From: Jason Wall <jwall@ausgrid.com.au>
Sent: Wednesday, 8 April 2020 3:36 PM
To: Louise Starkey
Cc: Development/Ausgrid; Paul Nakhle; Steve Head
Subject: RE: EIS Advice - Northside Private Hospital, West Gosford (SSD-10159)

From: Louise Starkey <louise.starkey@planning.nsw.gov.au>
Sent: Friday, 3 April 2020 11:03 AM
To: Jason Wall <jwall@ausgrid.com.au>
Cc: Development/Ausgrid <development@ausgrid.com.au>
Subject: EIS Advice - Northside Private Hospital, West Gosford (SSD-10159)

The Department of Planning and Environment has received a request for Secretary's Environmental Assessment Requirements (SEARs) for the Northside Private Hospital, West Gosford (SSD-10159). The proposed development is a State Significant Development under the Environmental Planning and Assessment Act 1979.

PLAN -1EXISTING OVER MAINS SCALE 1:1000

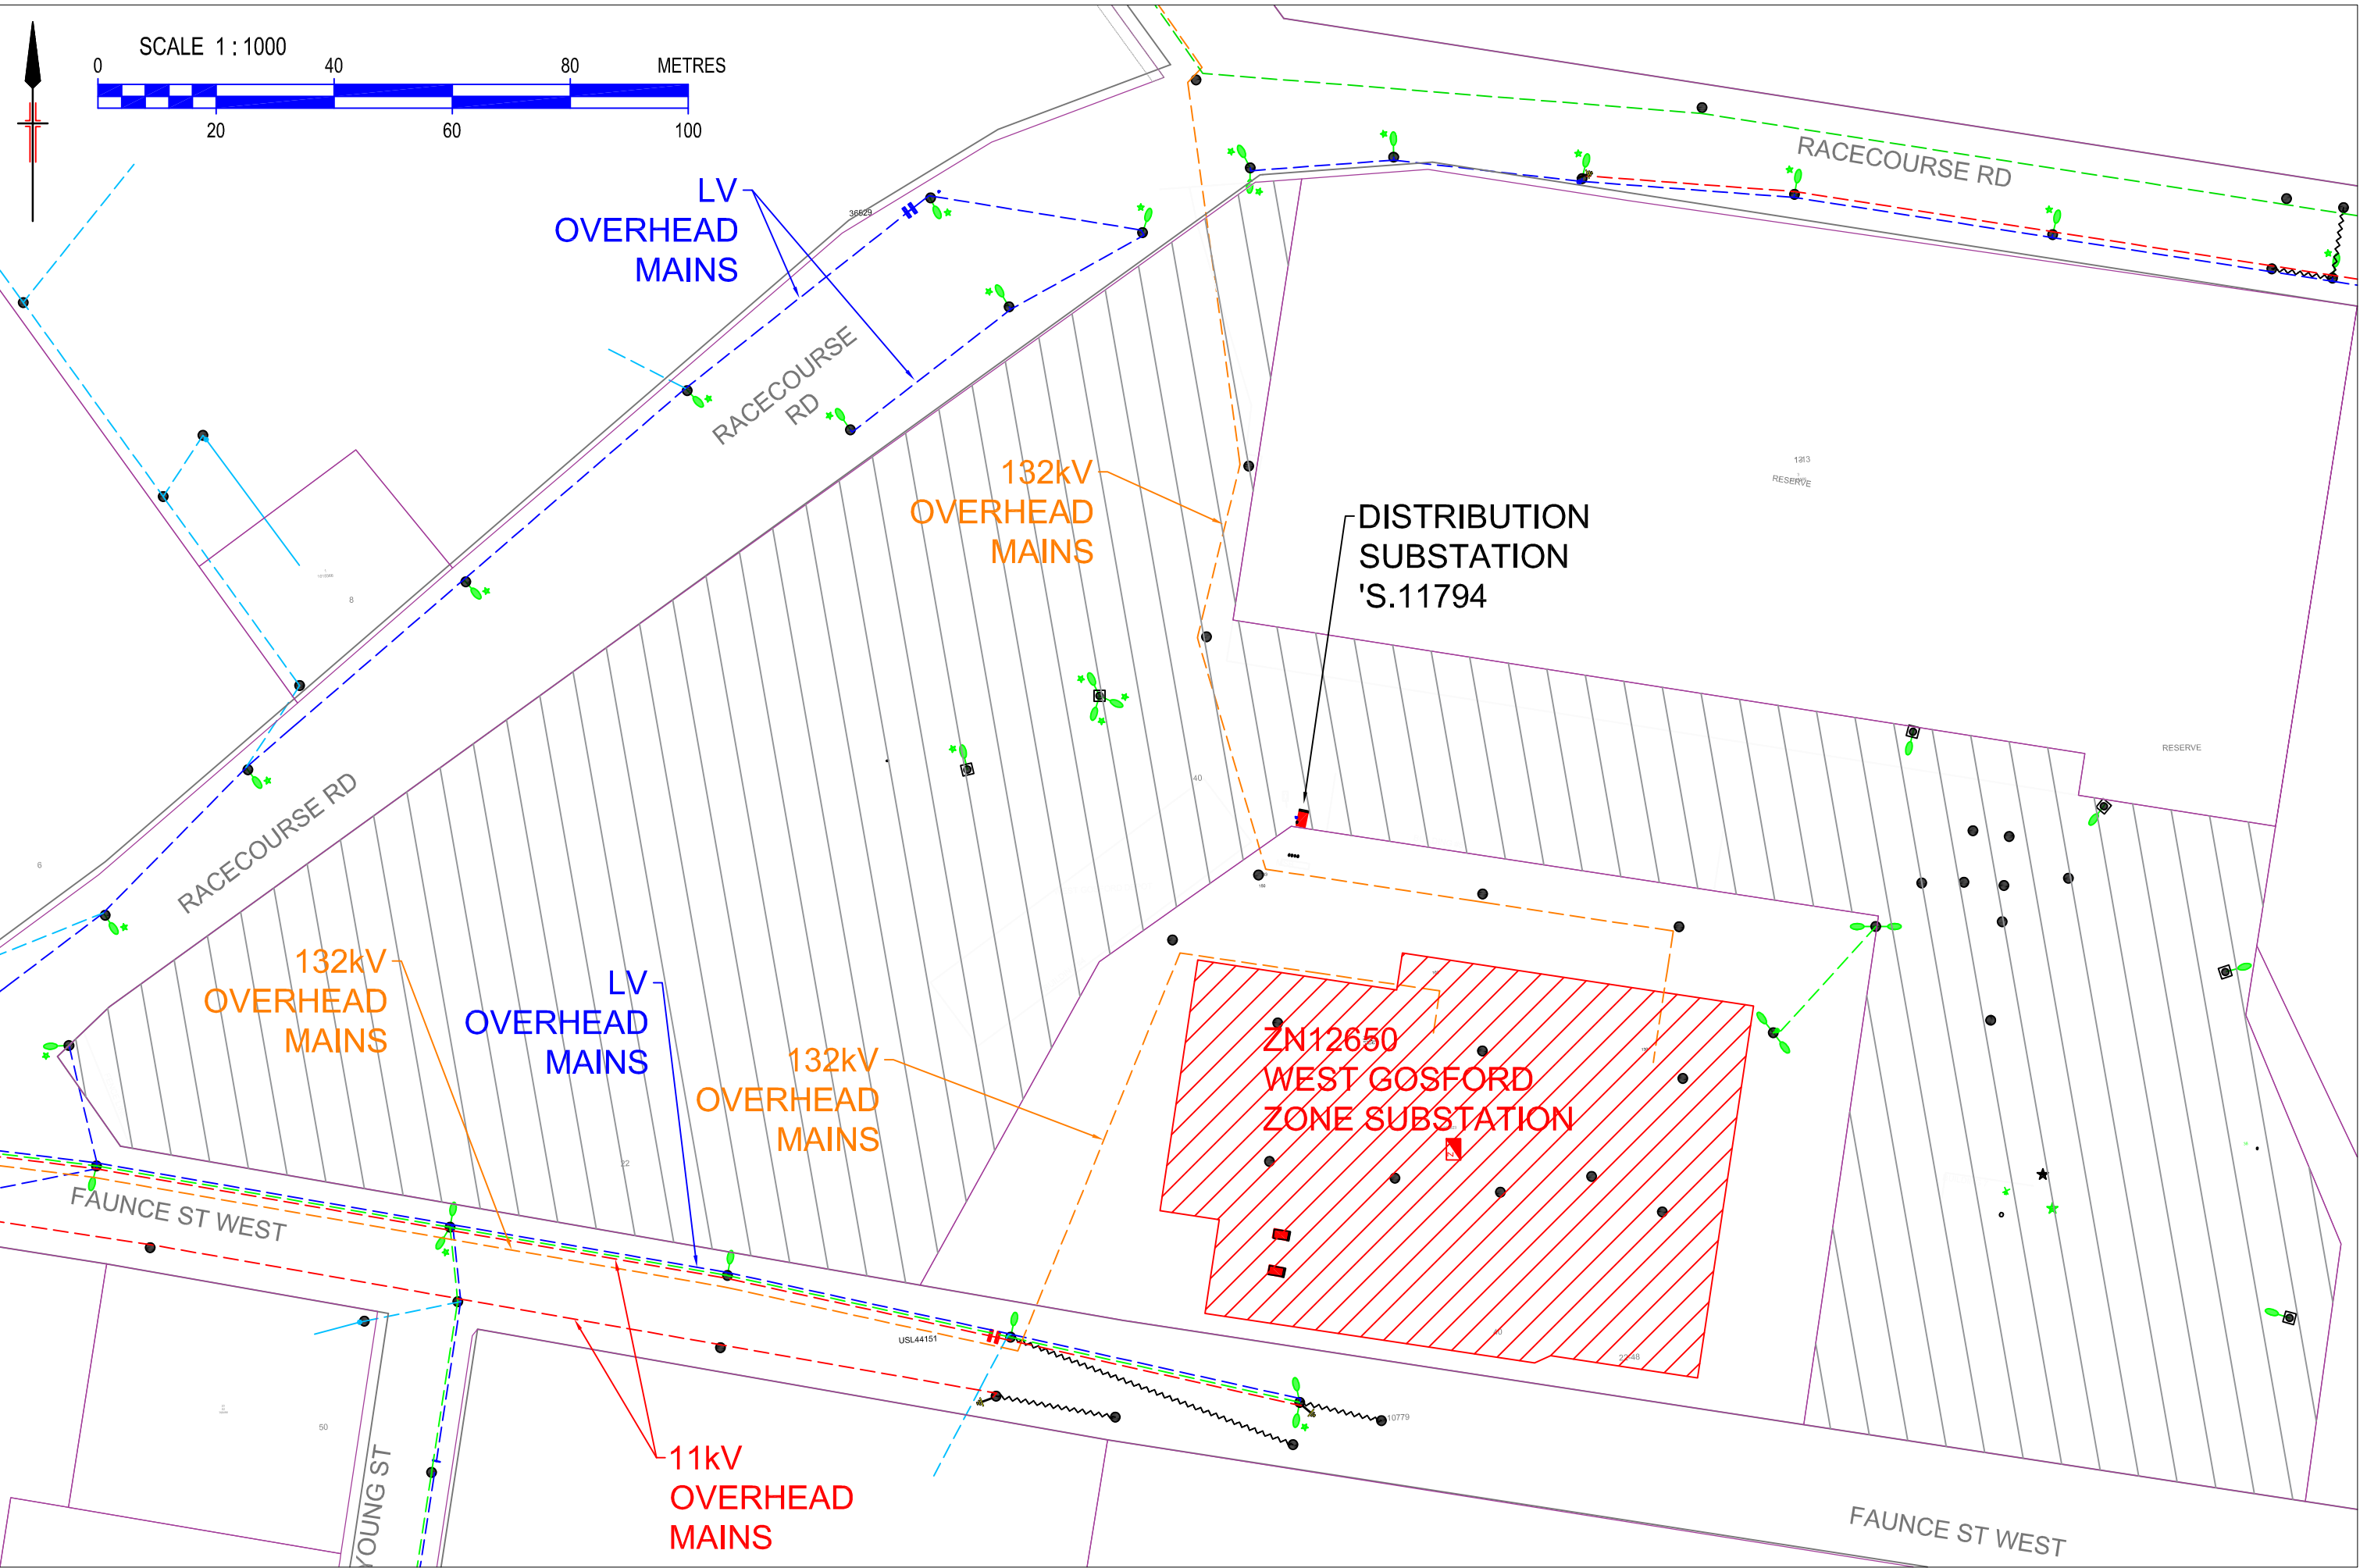
The proponent has also failed to address the SER's by providing any detail regarding how the development will be supplied from the Ausgrid Network and how the existing Ausgrid assets within the site will be treated. Ausgrid's view is that there are some significant cable relocations required for the development with respect to the 66kV overhead poles and wires on the site.
